CITY OF ALBUQUERQUE

Re: MWS LLC Warehouse, 2501-B Karsten Court SE, Traffic Circulation Layout
Engineer's Stamp dated 11-16-04 (M14-D12H)

Re: MWS LLC Warehouse, 2501-B Karston Court SE, Grading and Drainage Plan

TRAFFIC CIRCULATION PLAN

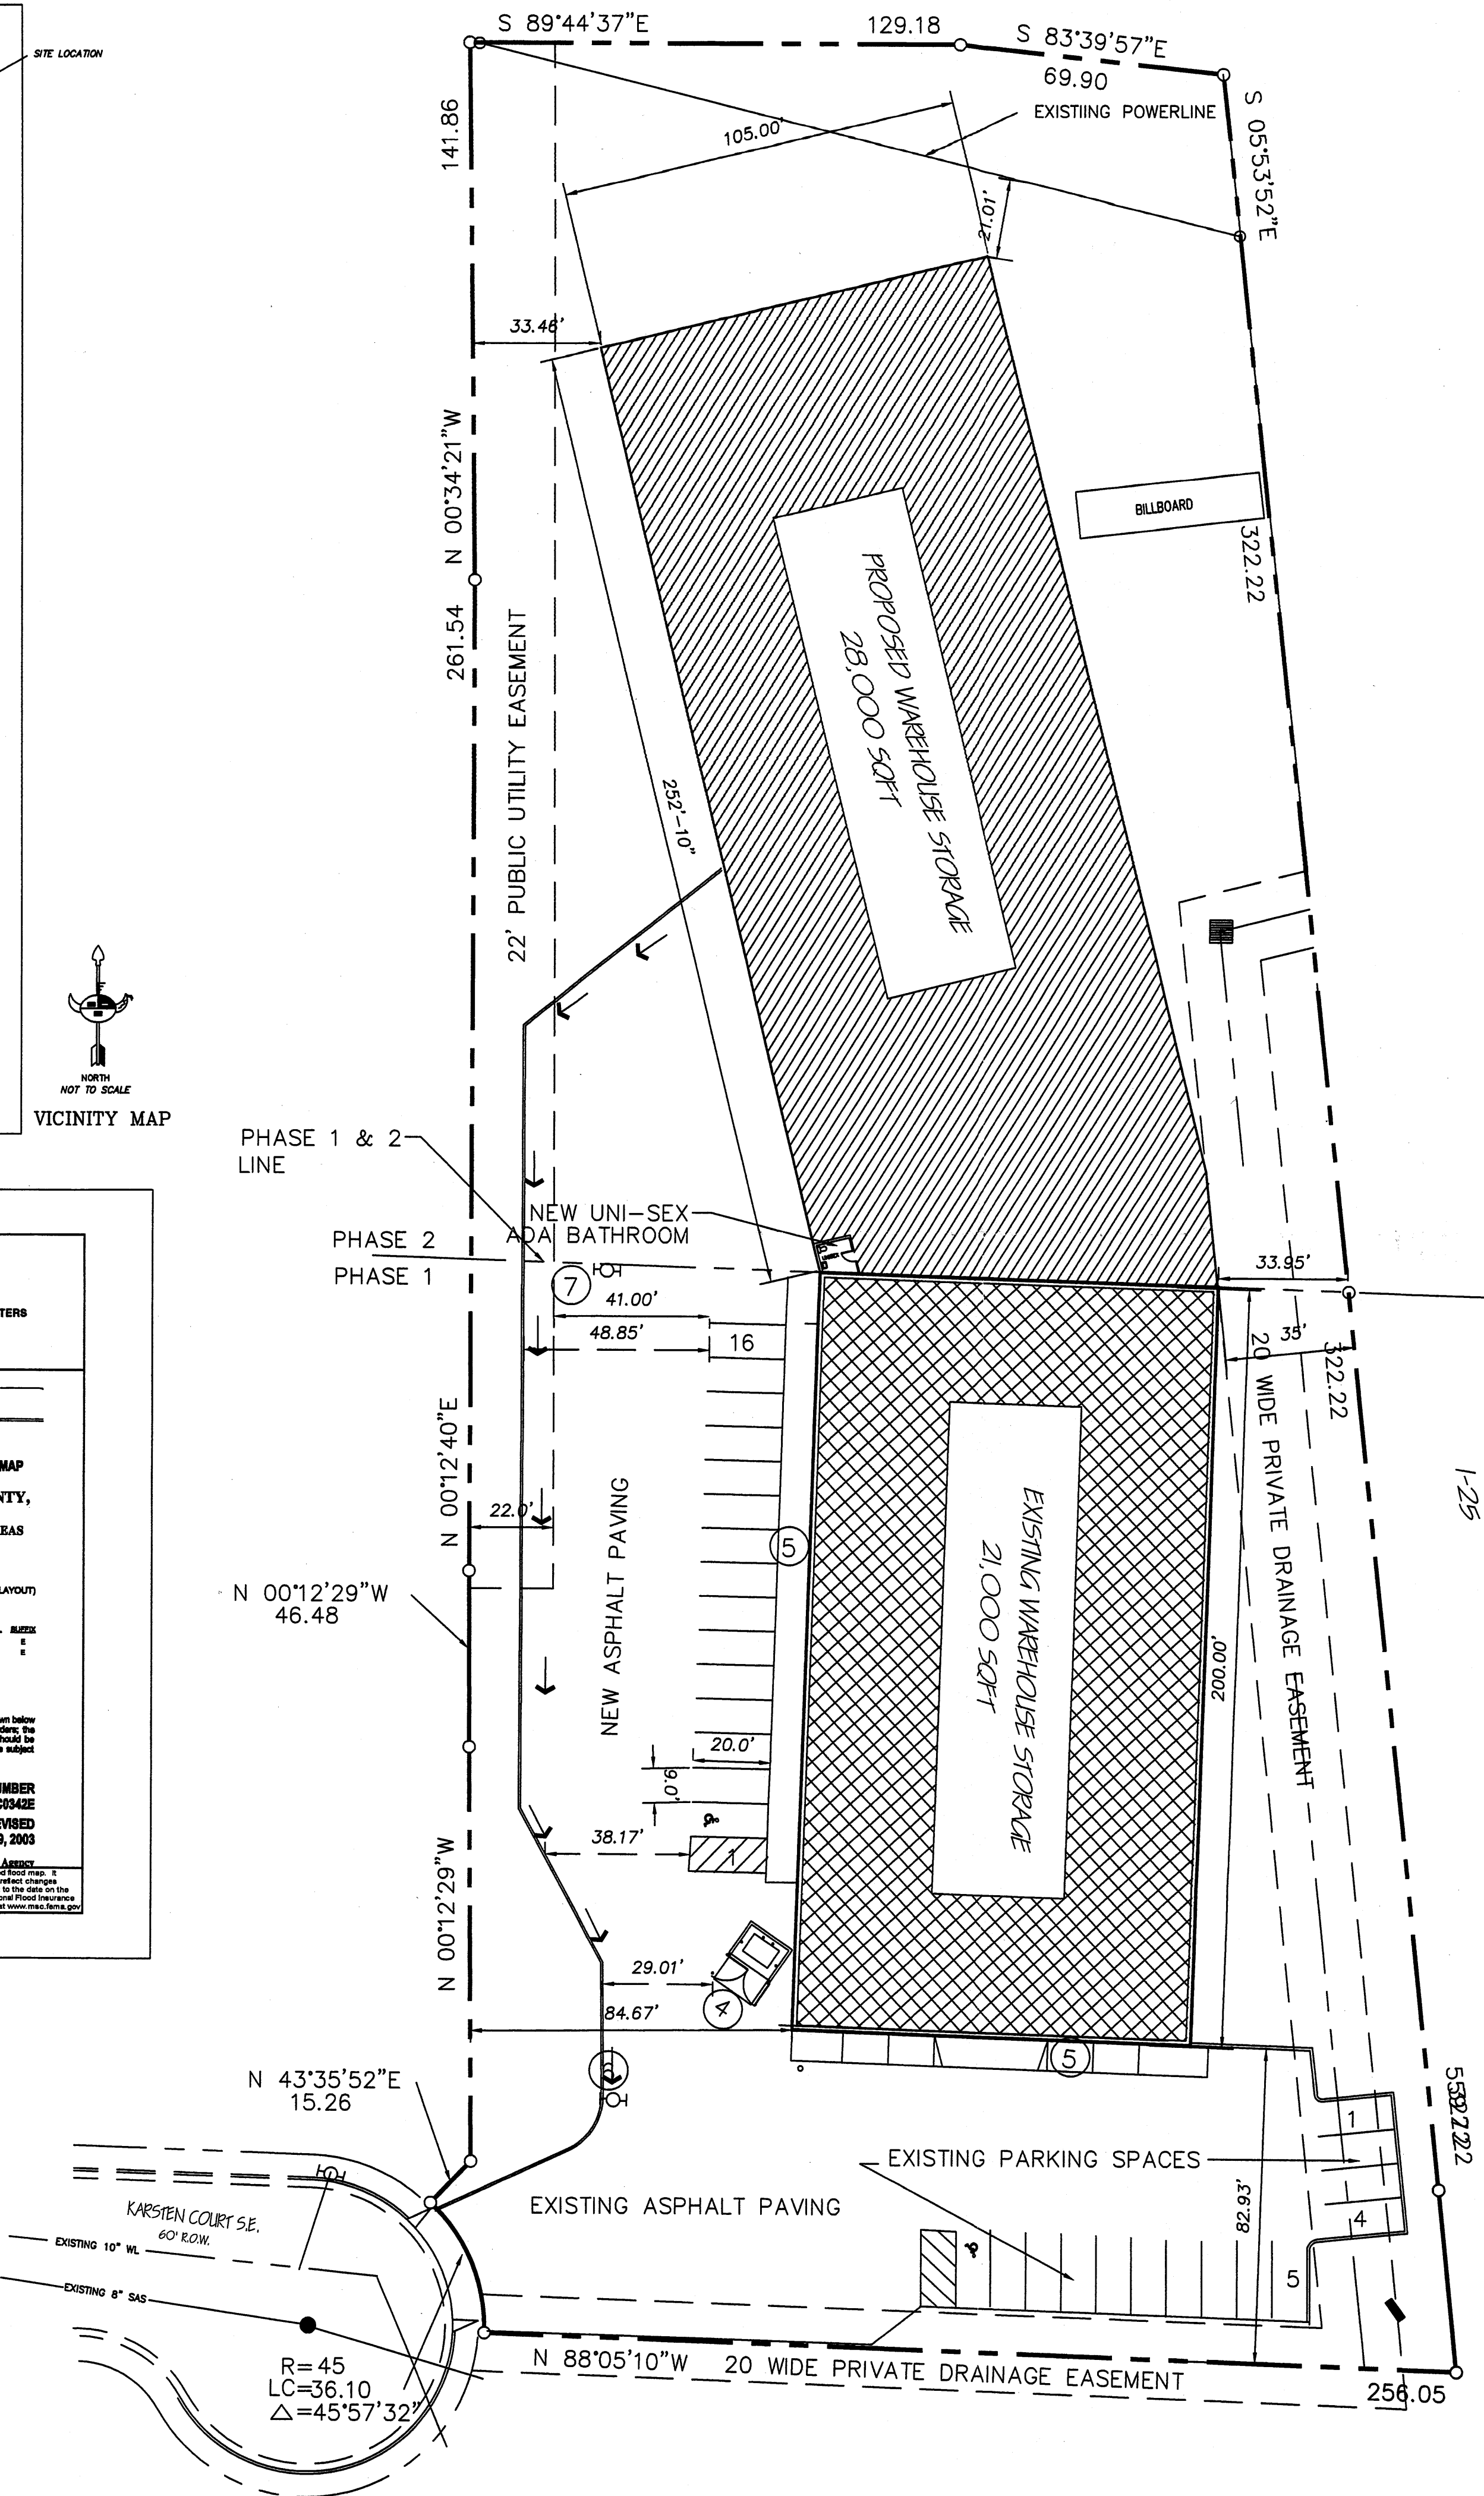
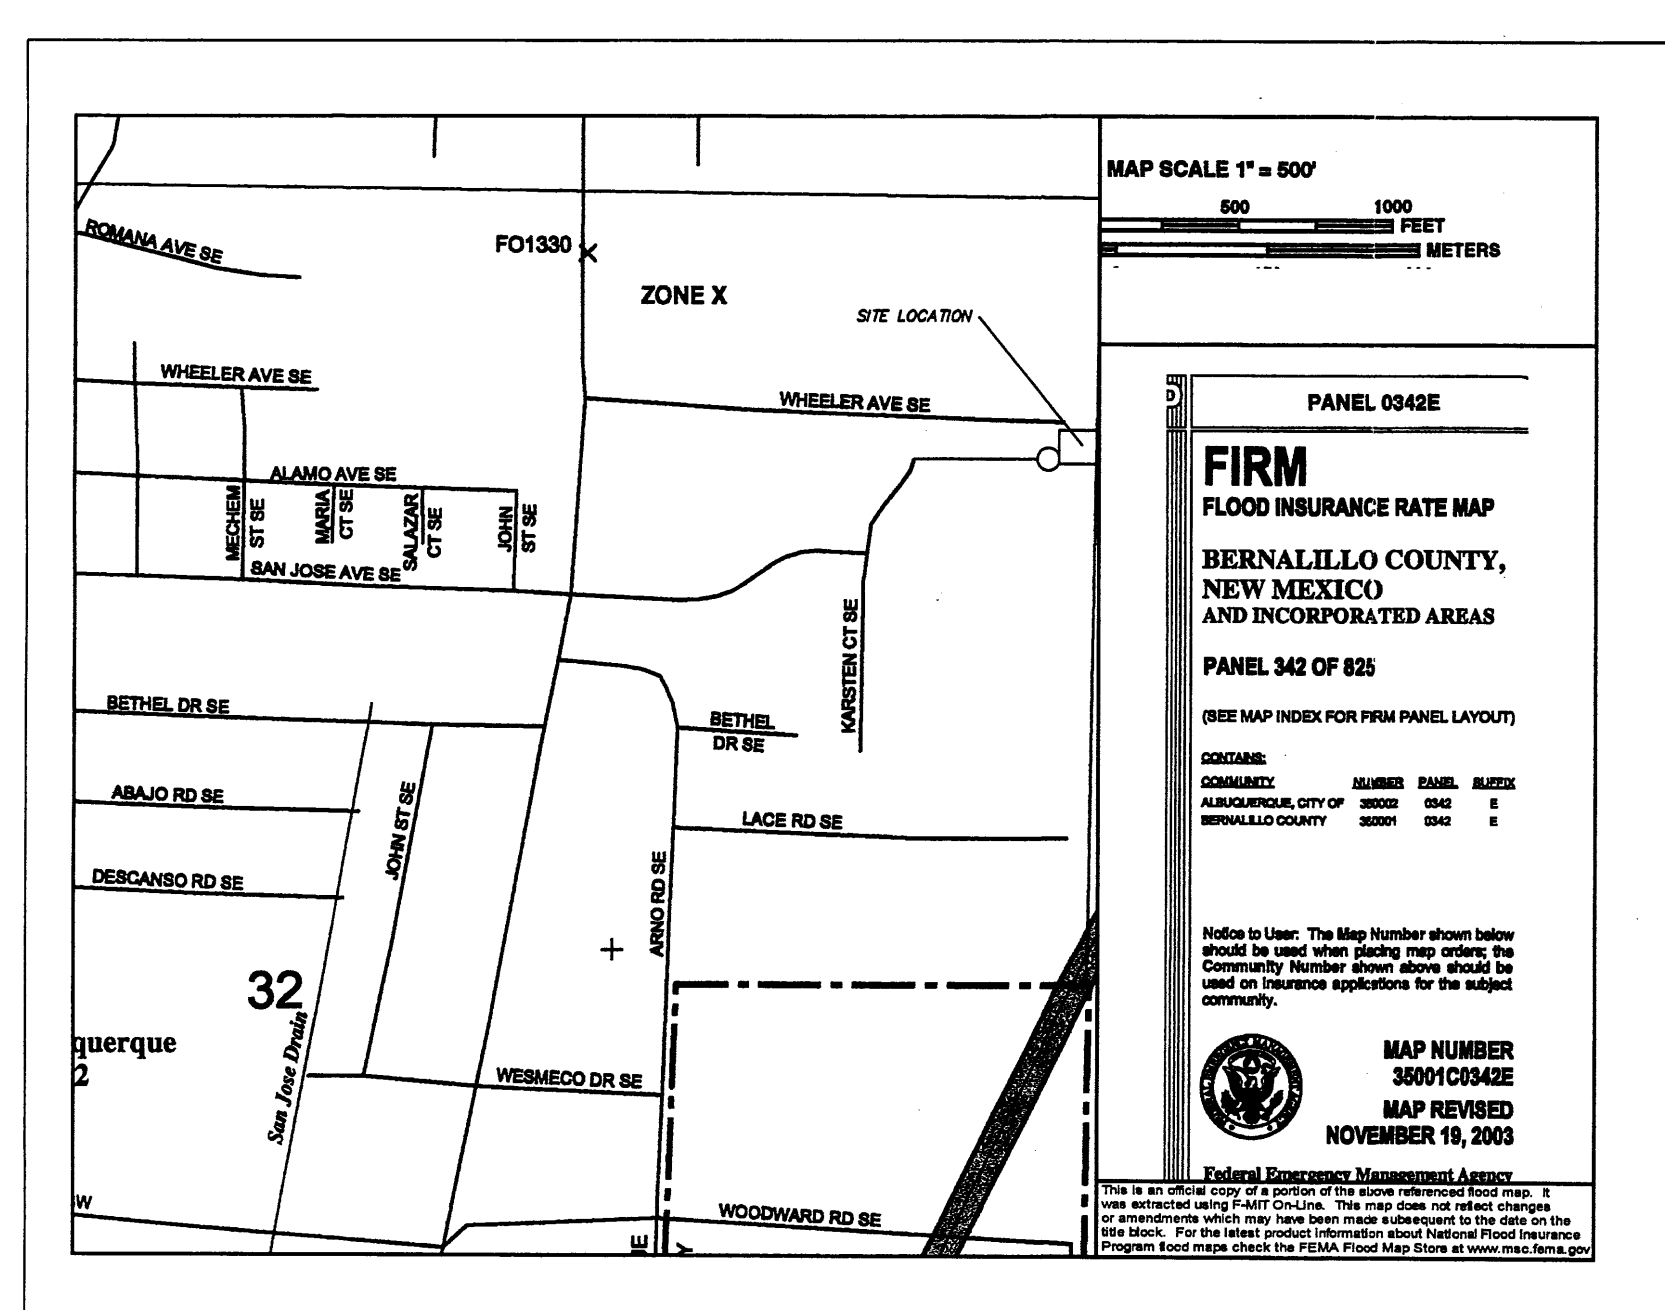
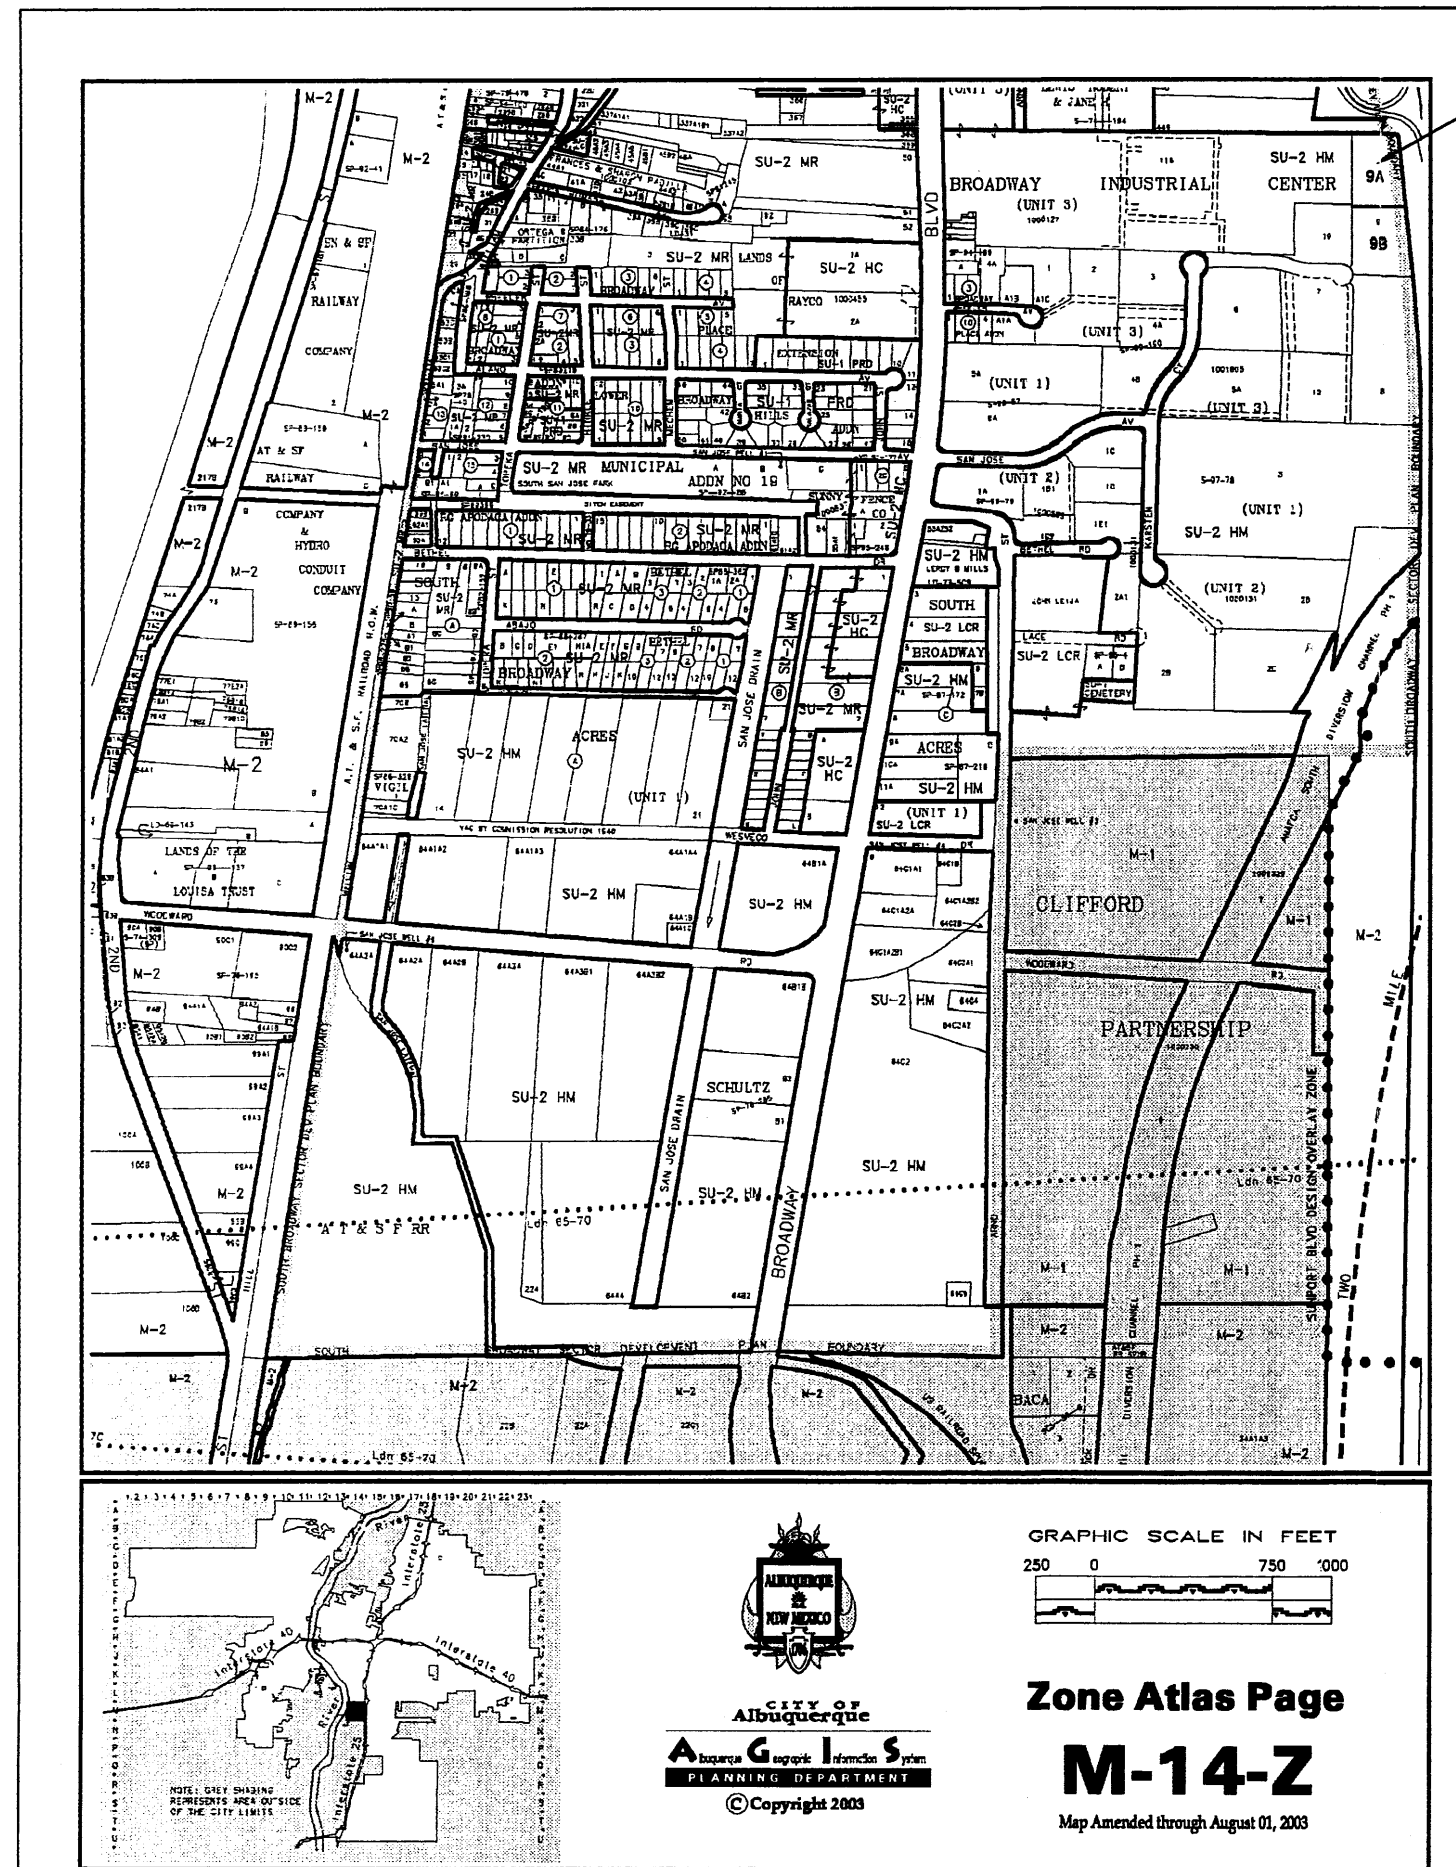
~~Label~~ All Division on parking stall

~~Label~~ All curves (Radius)

~~Provide~~ width of entrance

~~At site~~ widths

where is new phase
